## DECISION DELEGATED TO HEAD OF PLANNING

**Application No:** H12-0623-25      **Applicant:** Mrs J Williamson  
**Proposal:** Change of Use of Agricultural Buildings to 5 Dwellings  
**Location:** Villa Farm Lutton Garnsgate Spalding  
**Terminal Date:** 27th August 2025

GROUND FLOOR PLAN - PROPOSED 1:100

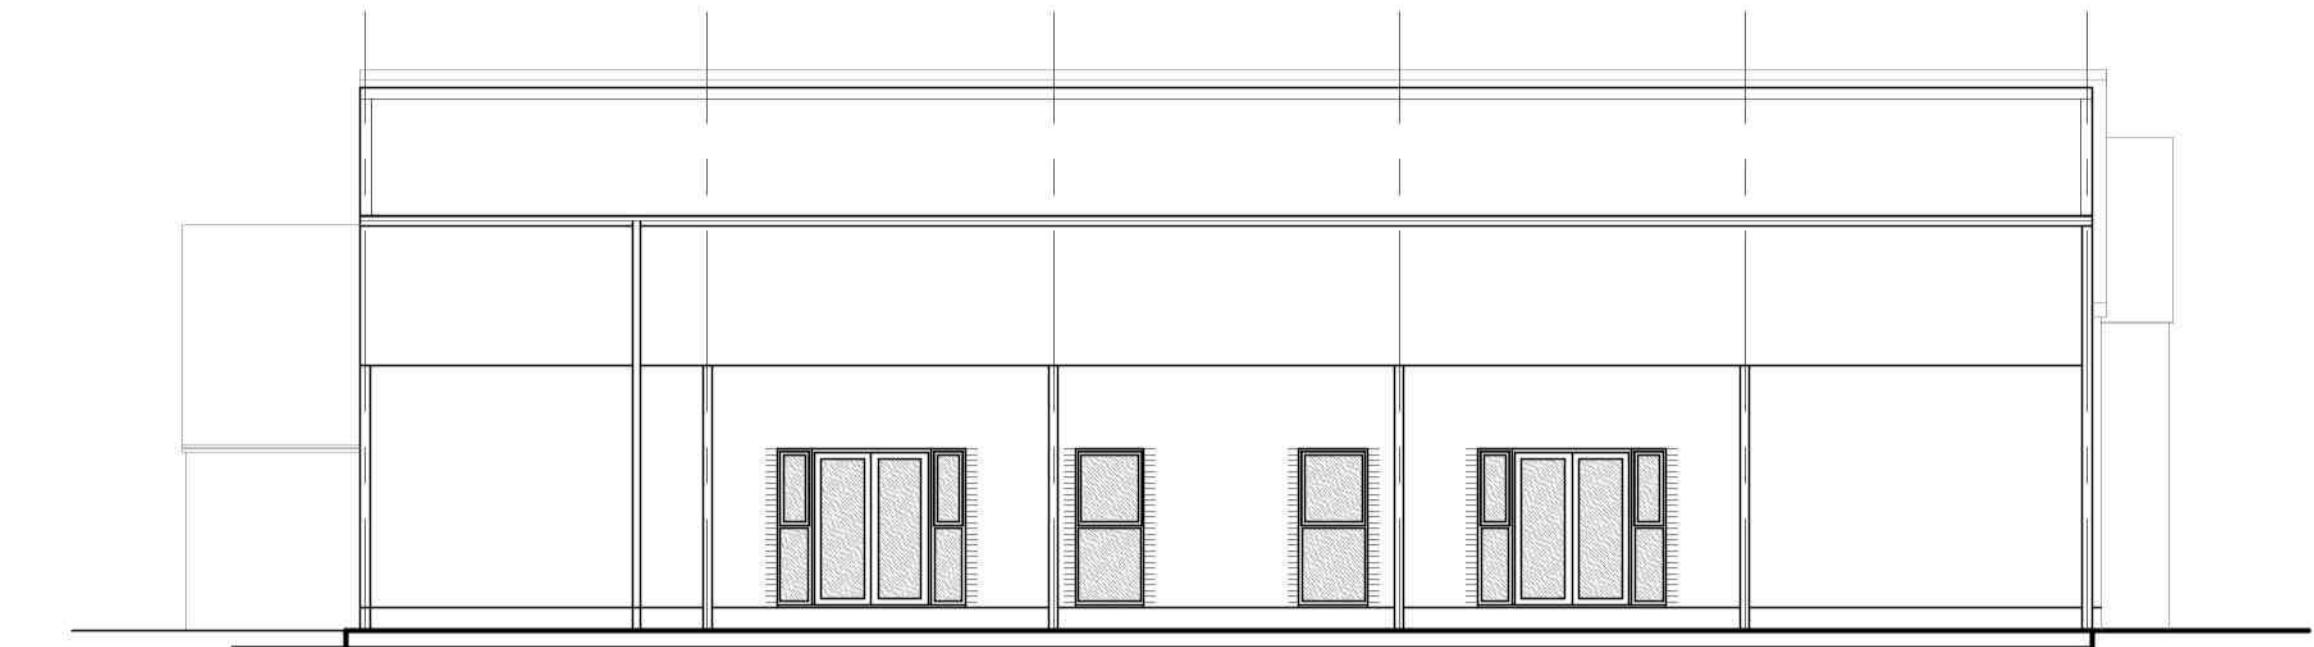
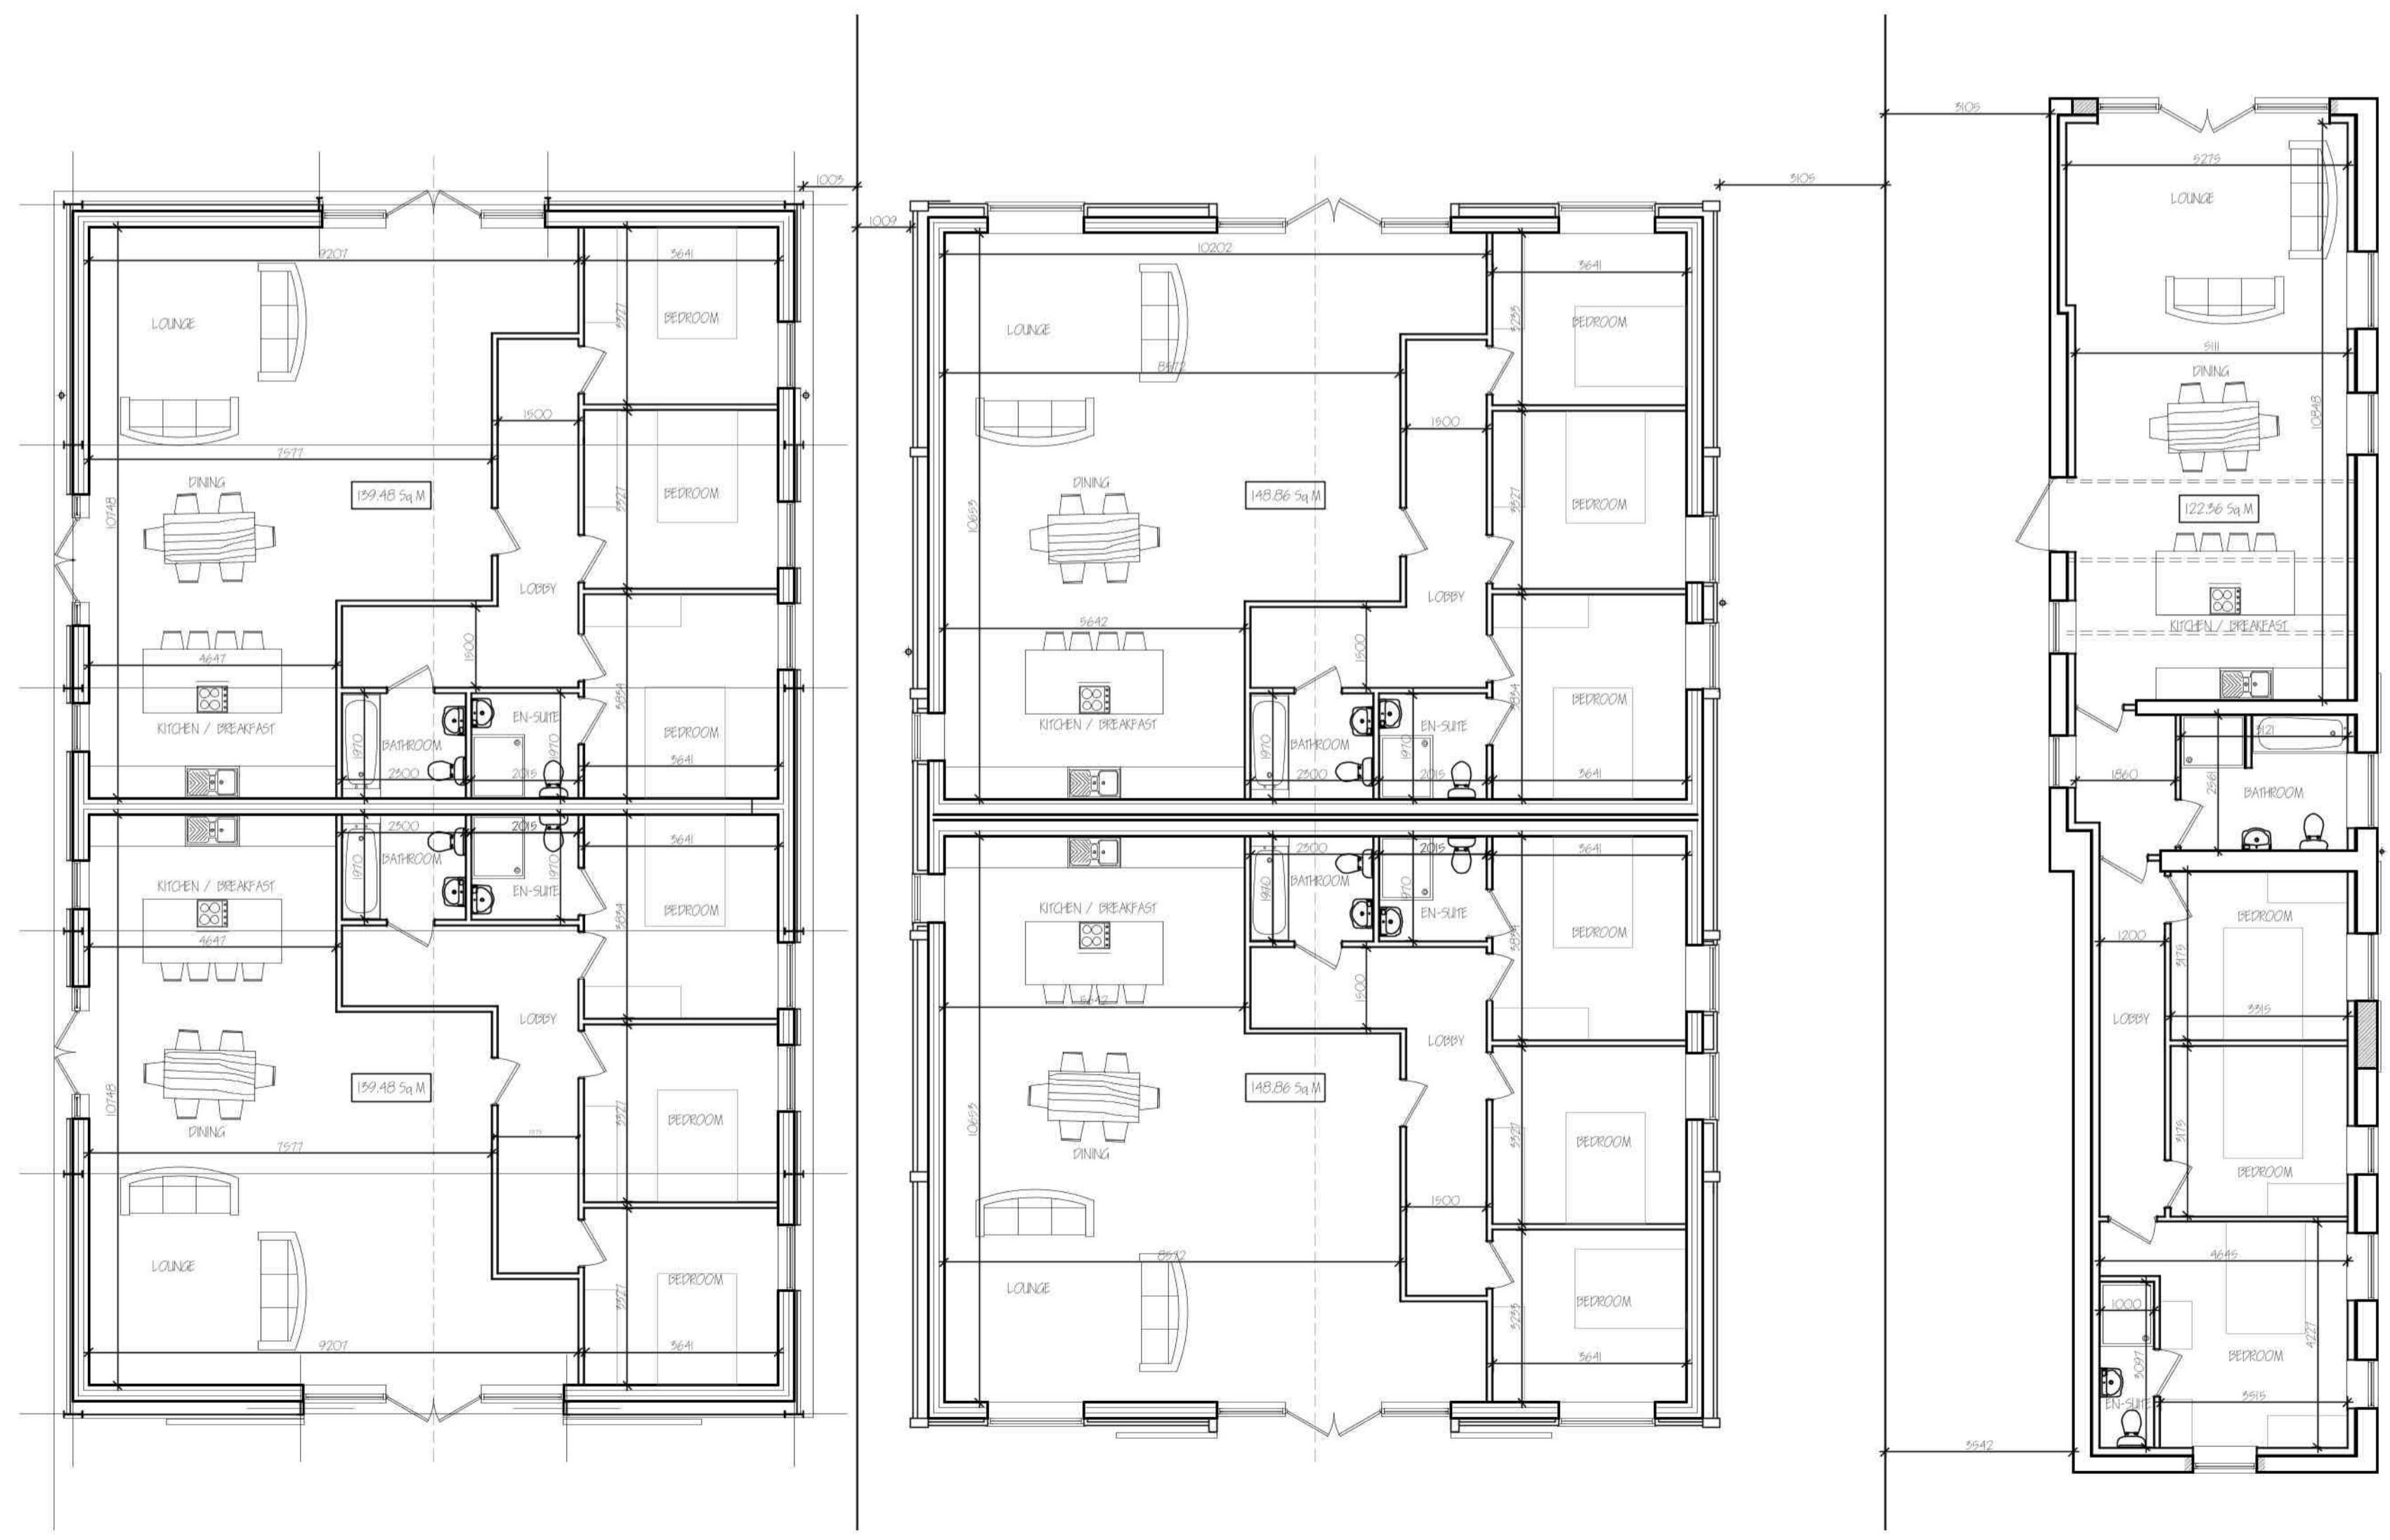
On dwellings 1, 2, 3 and 4, the proposed materials include grey profile metal sheeting and a grey standing seam roof. On dwellings 3 and 4, it is proposed to retain the existing grain walling on the bottom half of the building. For dwelling 5, it is proposed to remove the existing white paint from the brickwork facades. The existing tiled roof is proposed to be reclaimed to match the existing. Black aluminium windows and doors and black metal rainwater goods are proposed for all of the dwellings.

SITE PLAN - PROPOSED - 1:250

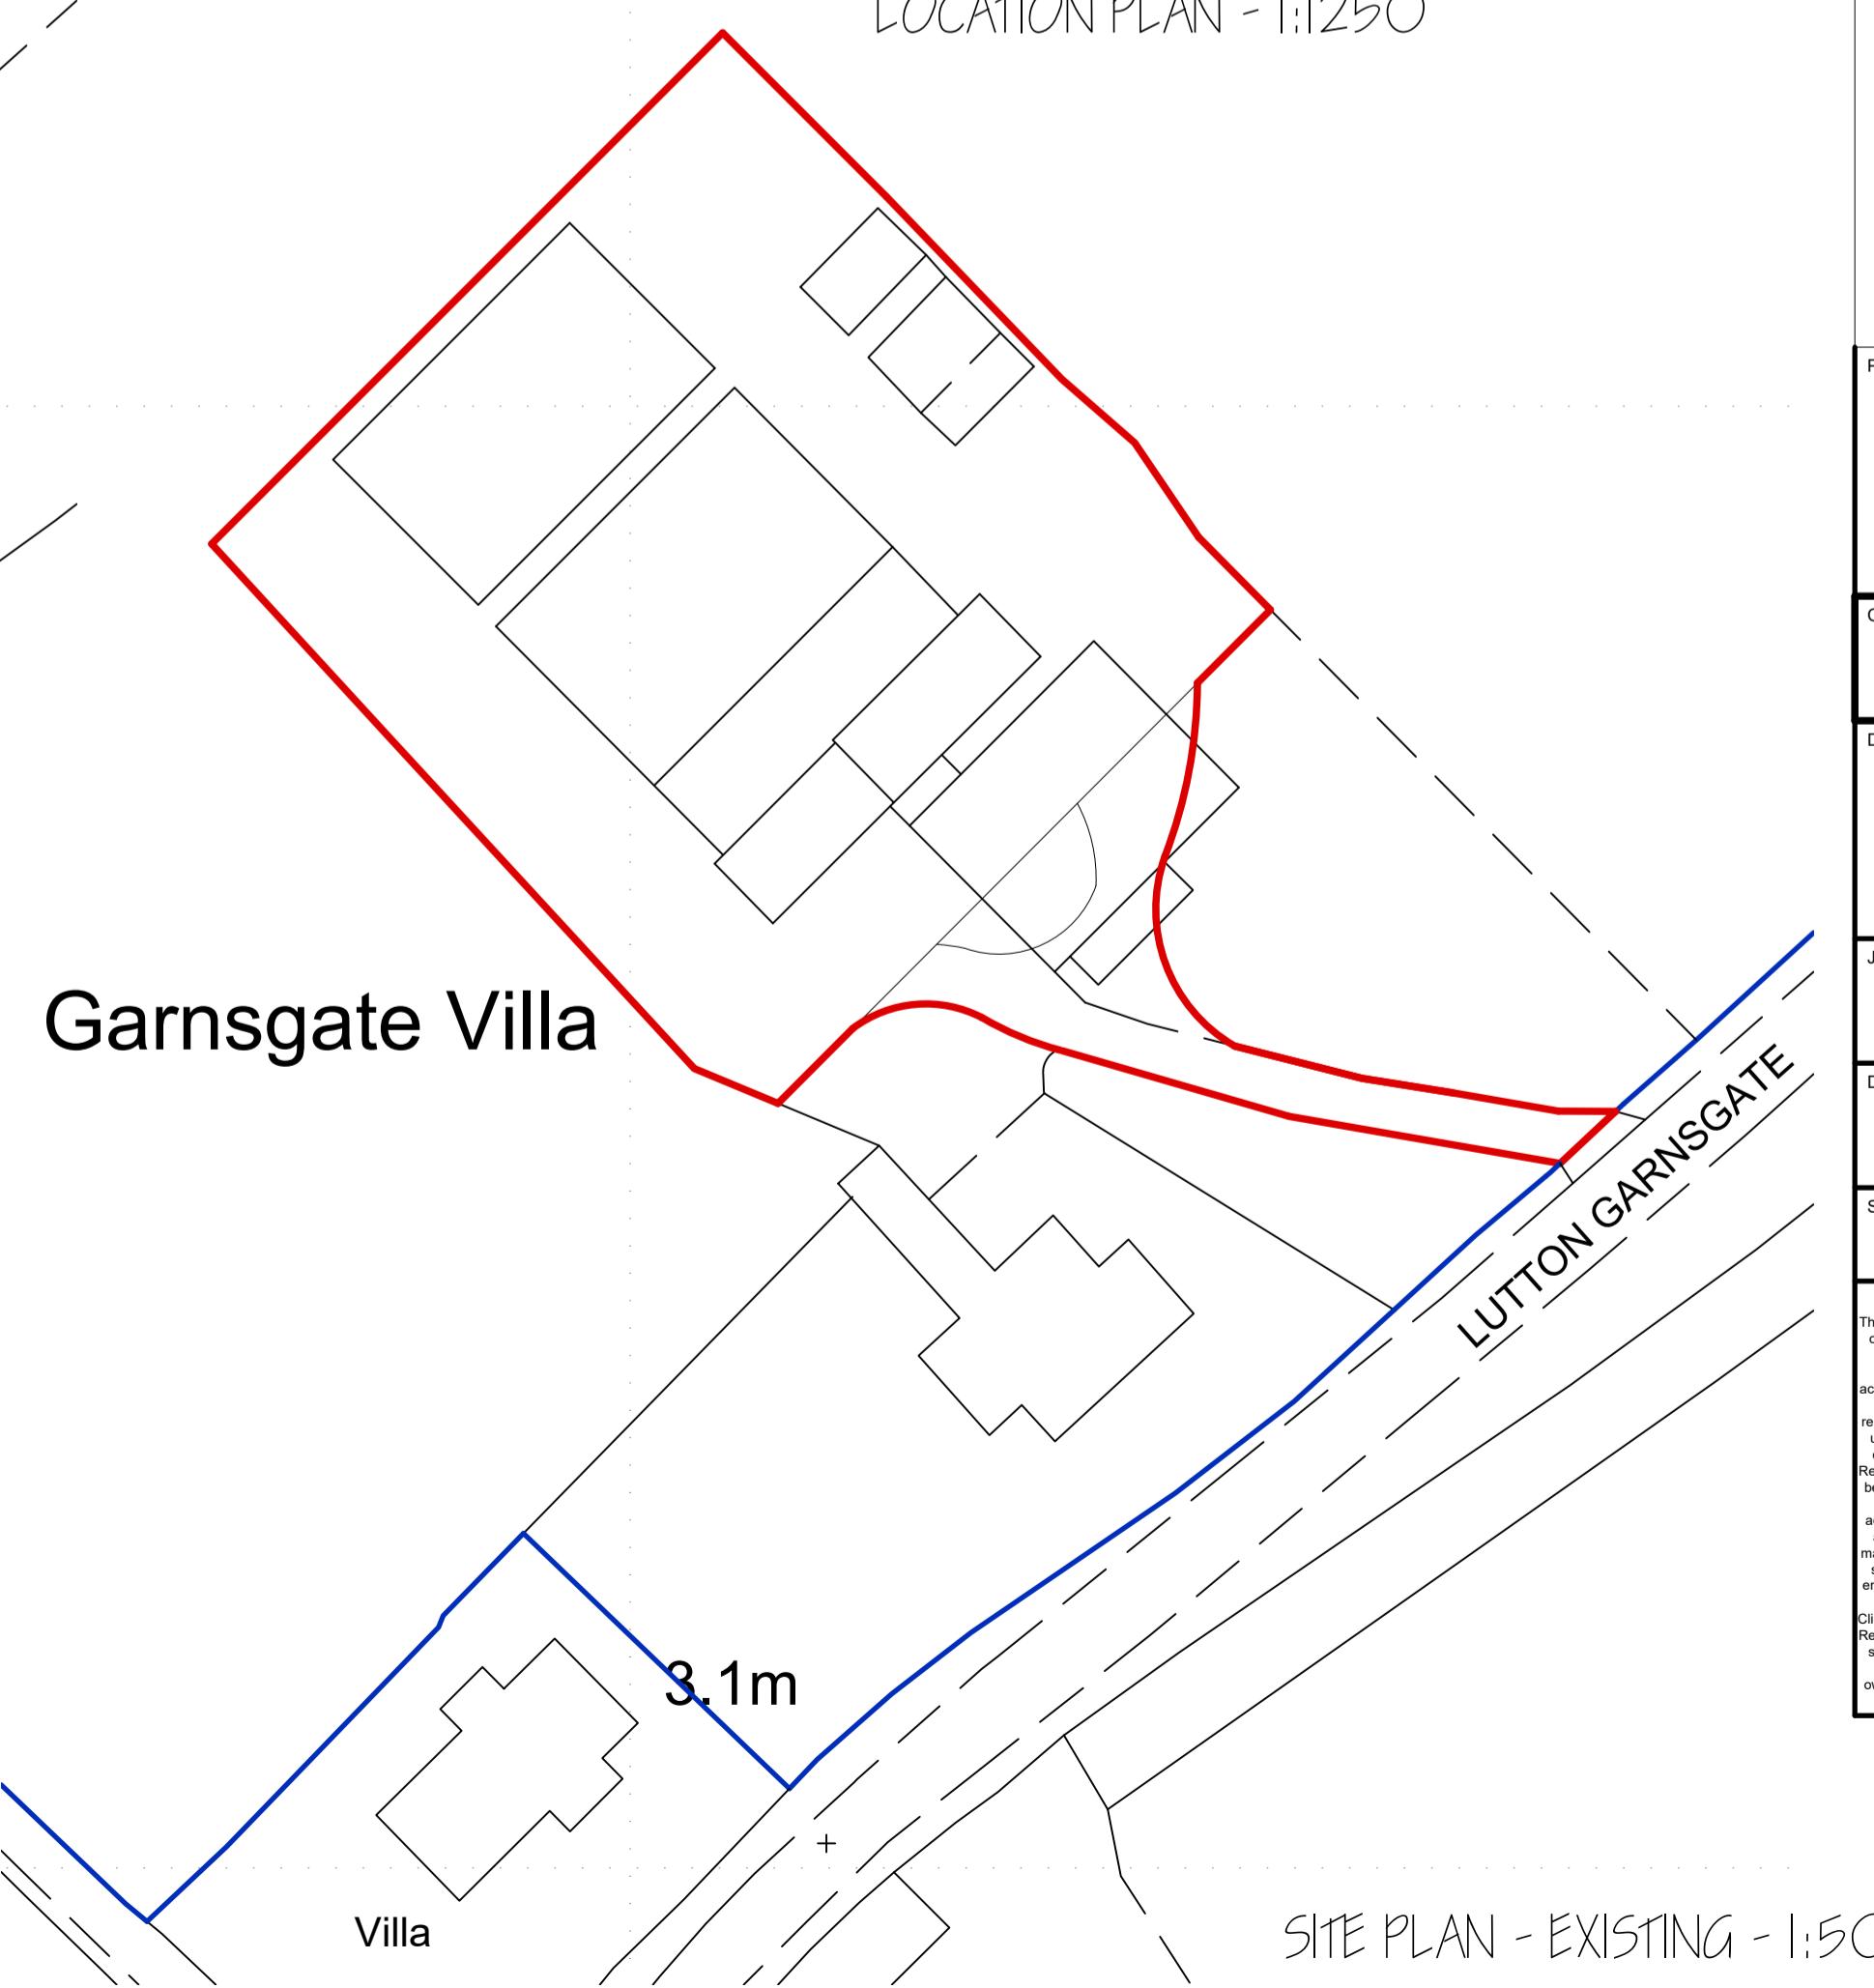
Lincolnshire County Council - Highways and SUDS: The access is to be 4.1m for the first 10m and thereafter 3.7m - needs to be detailed on plan.

The proposed access to the site is from Lutton Garnsgate, which is to the south-west of the site. Lincolnshire County Council's (LCC) highways team requested that the access measures 4.1m for the first 10m and 3.7m thereafter. The site plan has been updated accordingly. Parking is shown for each of the dwellings. There is considered to be adequate room for parking and turning within the site for each of the dwellings.
